Rezoning Transportation Analysis

Petition Number: 2023-013

Date	Description
05-24-2023	First Review (PDM)
07-28-2023	Second Review (PDM)
8.29.2023	Third Review (JP)

**RZ.01**

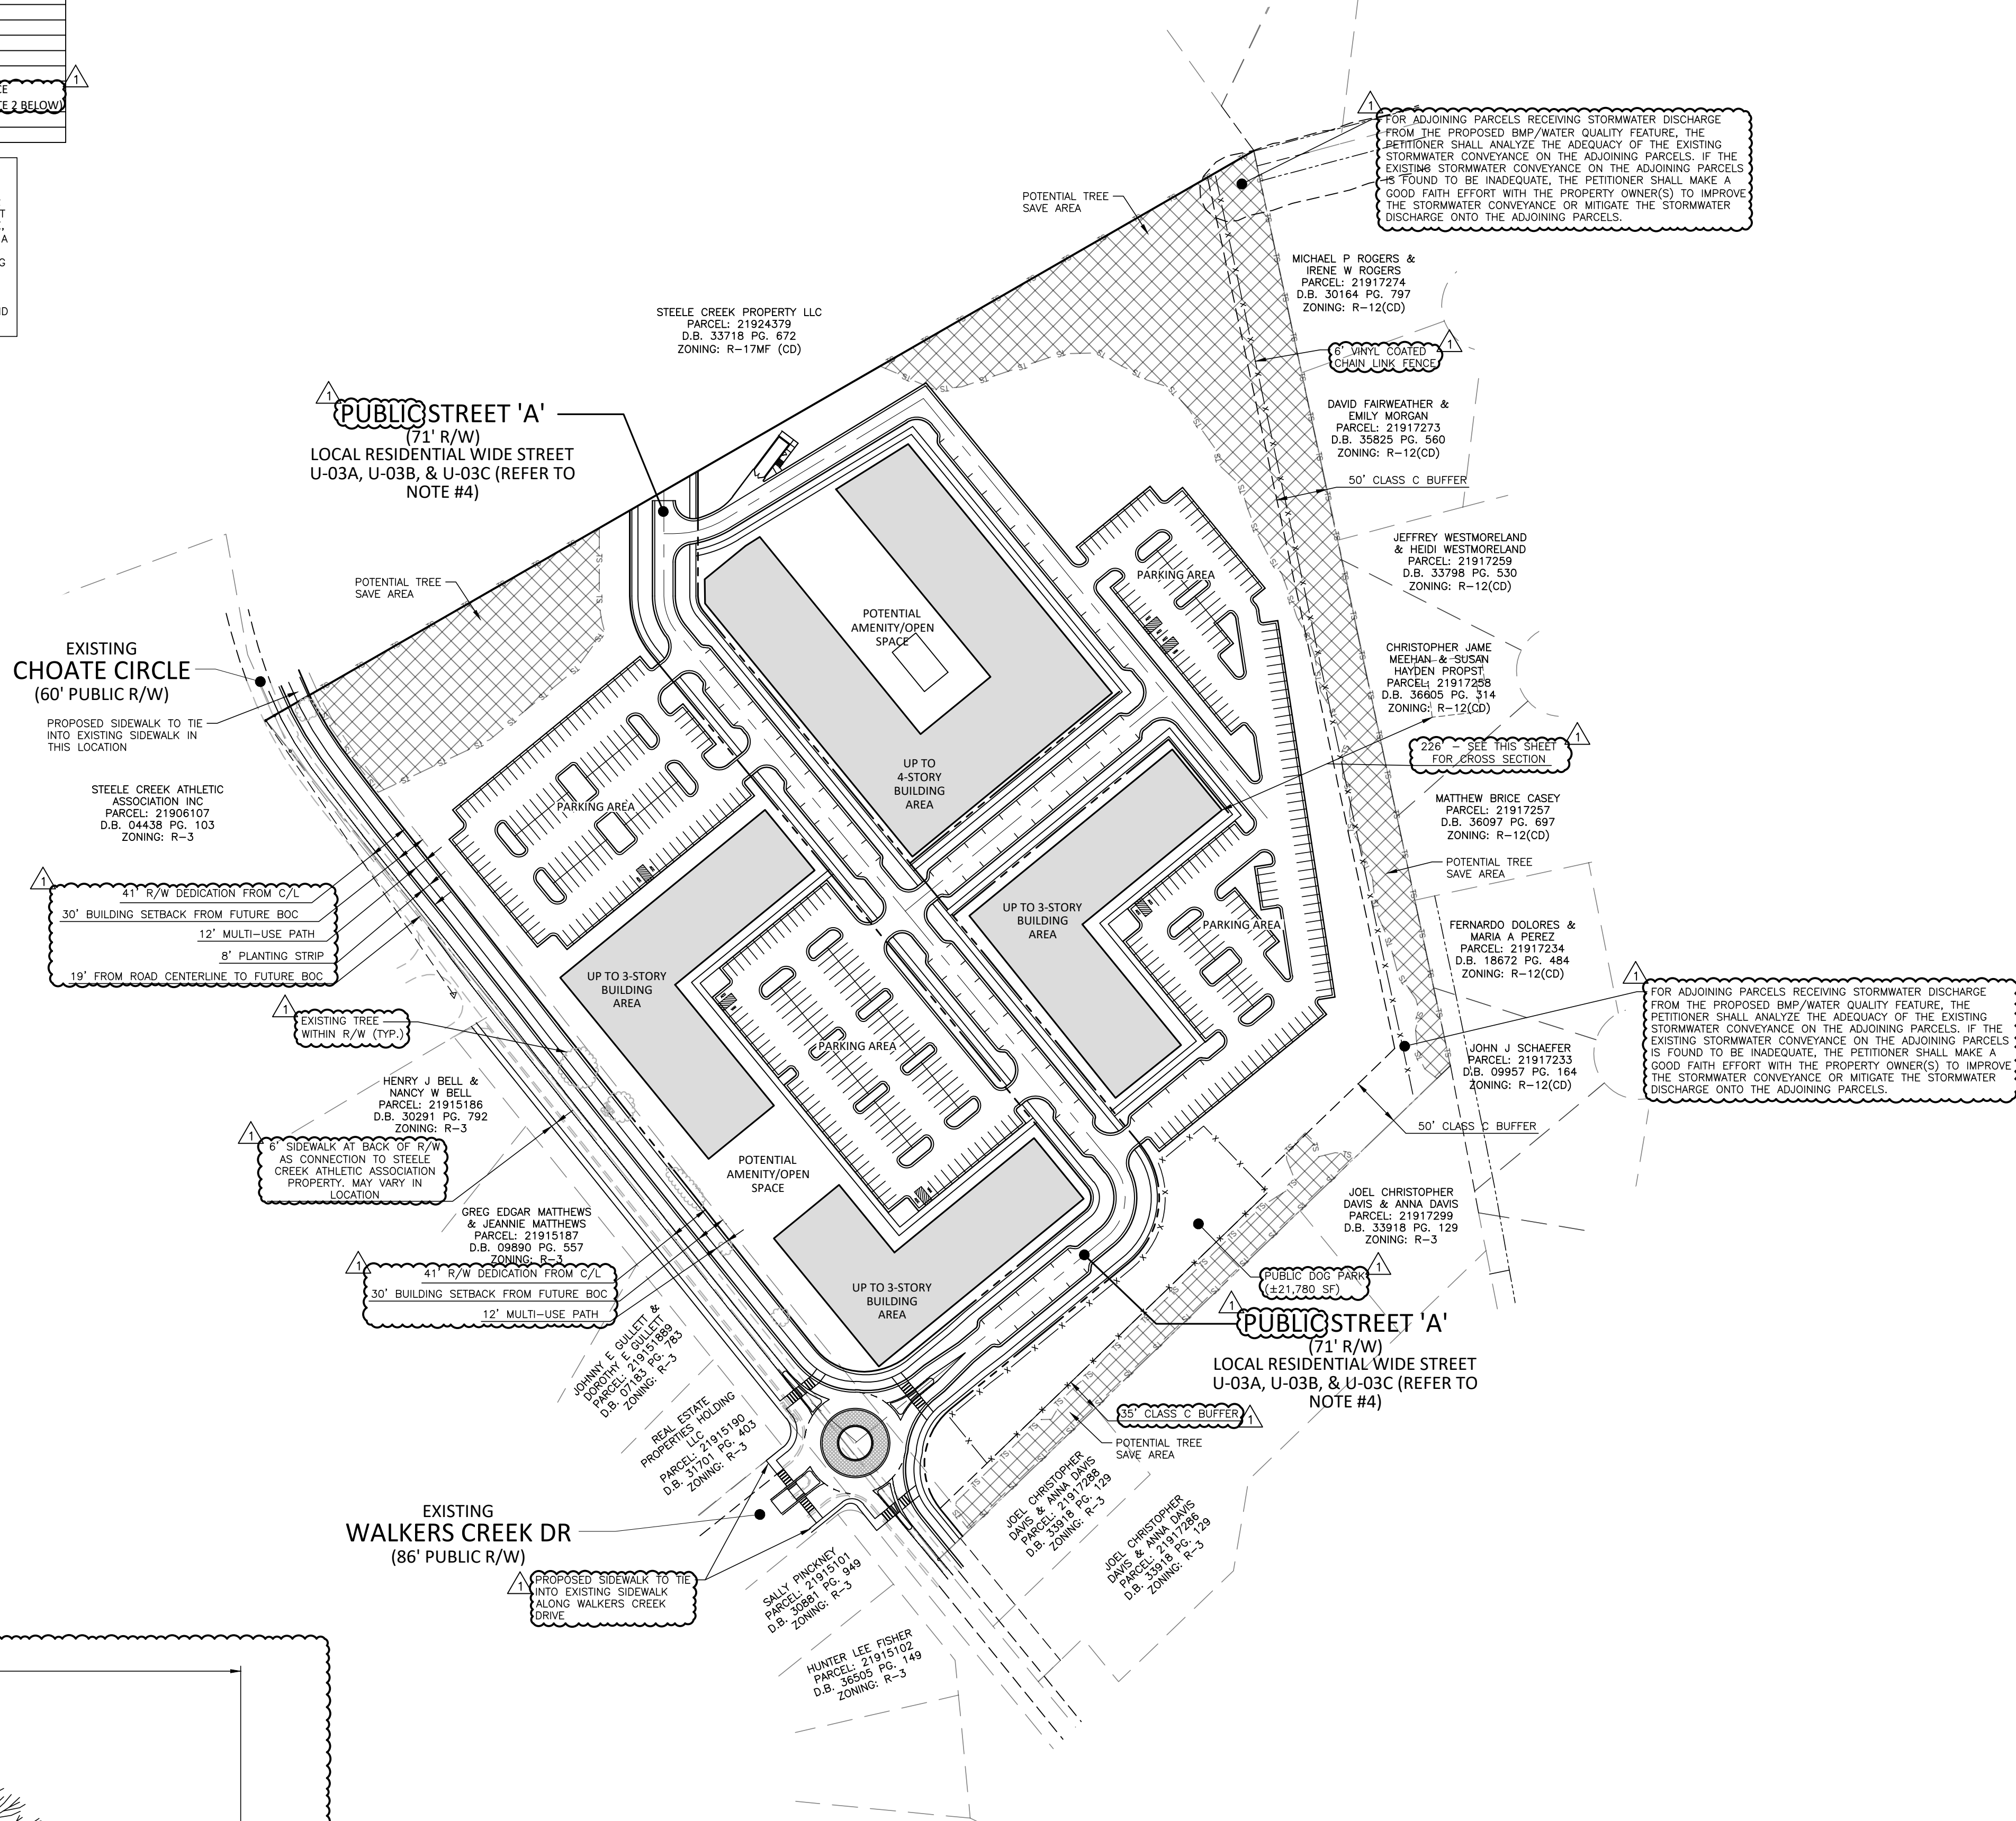
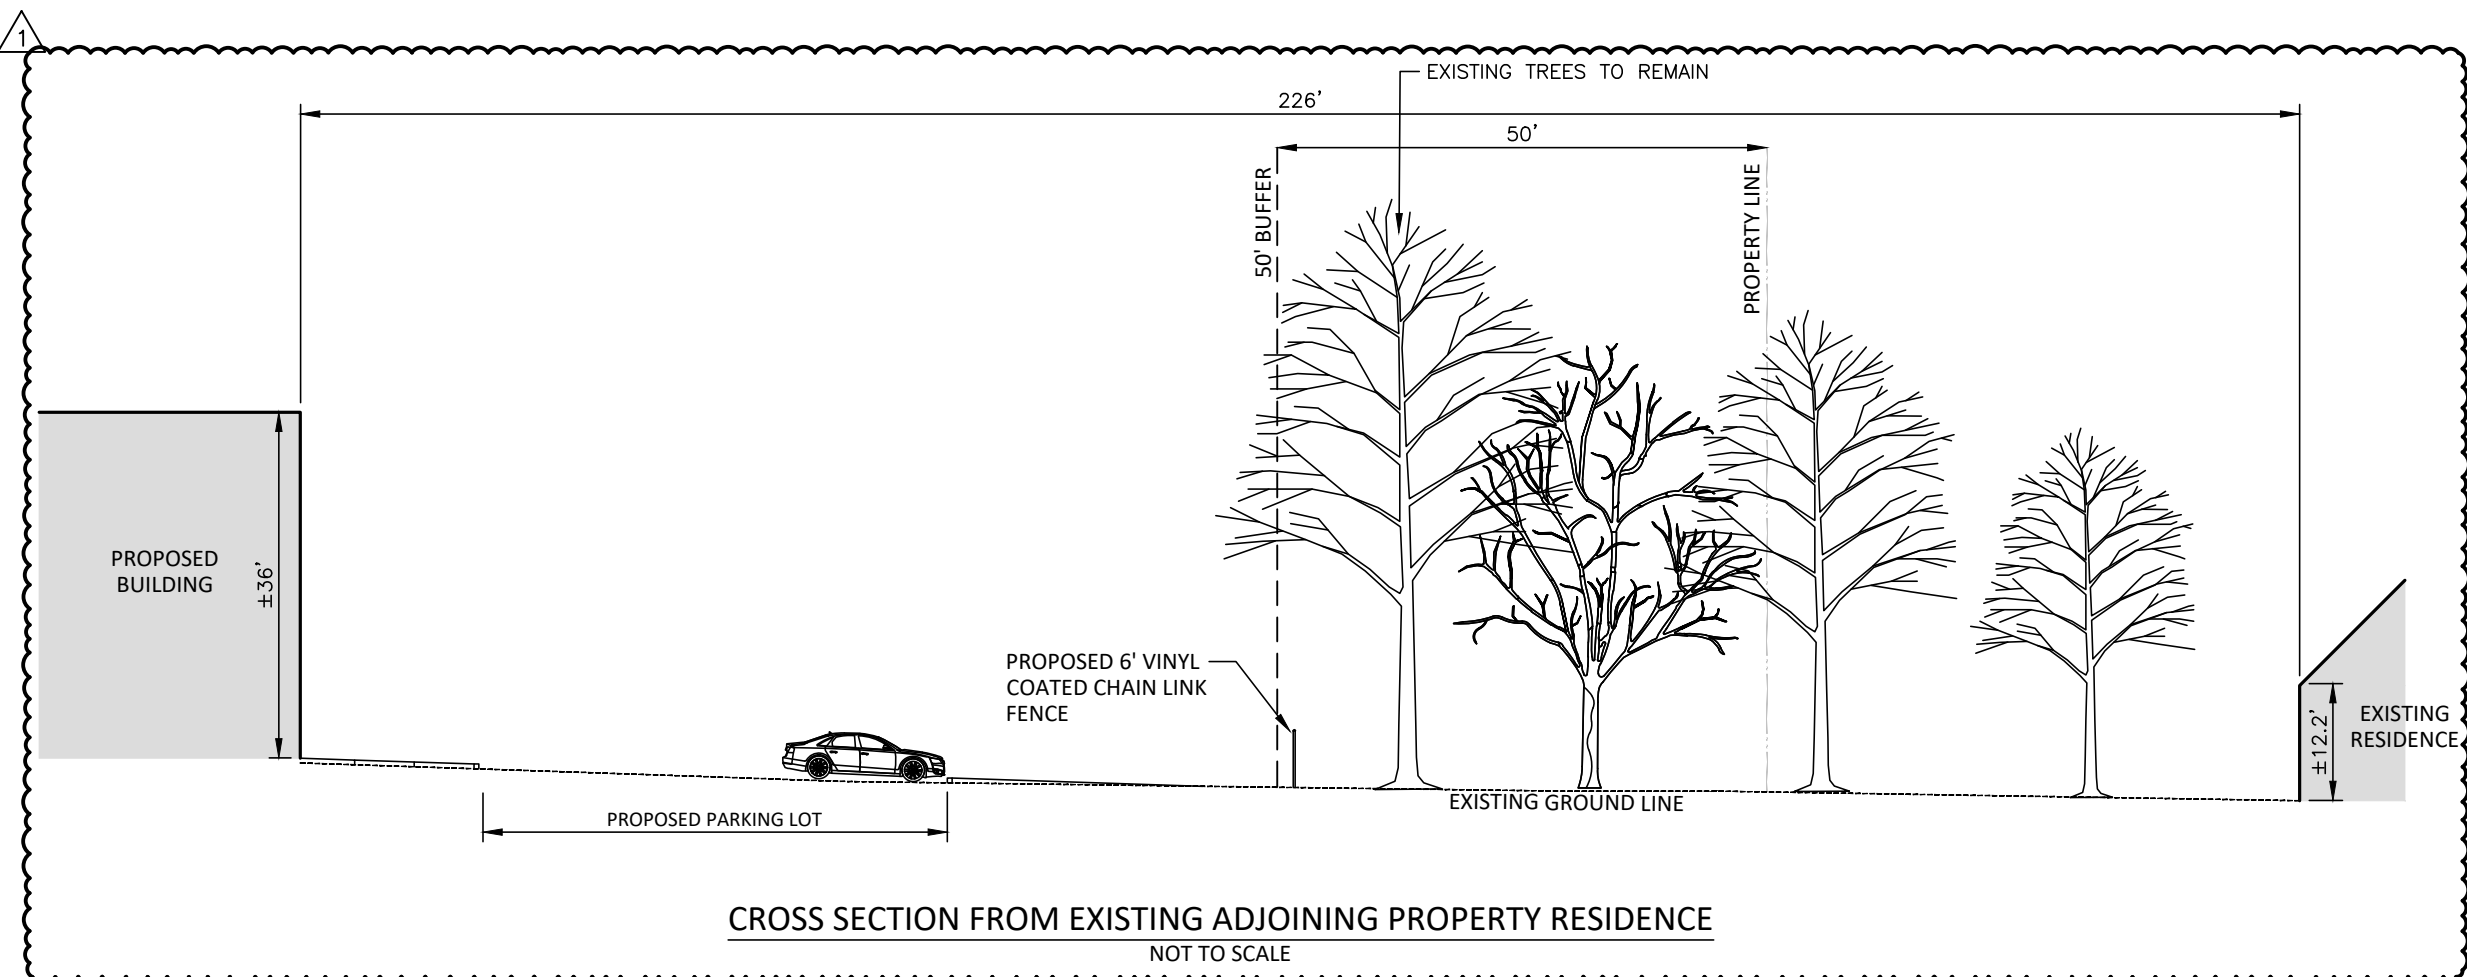
~~**Choate Circle:** Location of curb and gutter to be installed a minimum of 19 feet from roadway centerline to accommodate the Charlotte Streets Map with a roadway typical section of a 2+ Avenue.~~

~~Label and dimension the curb and gutter from the centerline for each road on the site plan.~~

4. ~~Revise site plan and conditional note(s) to commit to dedicate a minimum of 35 feet of right of way from the road centerline on Choate Circle. The site plan shall label and dimension the right-of-way from the road centerline. Provide SUE for multi-use path if located outside of the ROW.~~
5. **Outstanding Comment from 7.28.2023:** ~~Revise site plan and conditional notes(s) to convert the proposed private streets to public streets.~~
6. ~~Revise site plan and conditional note(s) to commit to construct bicycle facilities installing a 12' multi-use path and 8' planting strip to meet the Council-adopted Charlotte BIKES Policy. Multi-use paths maintained by the City shall meet ADA/PROWAG requirements.~~
7. ~~Revisit site plan to remove the left turn lane stop bar shown on Choate Circle.~~
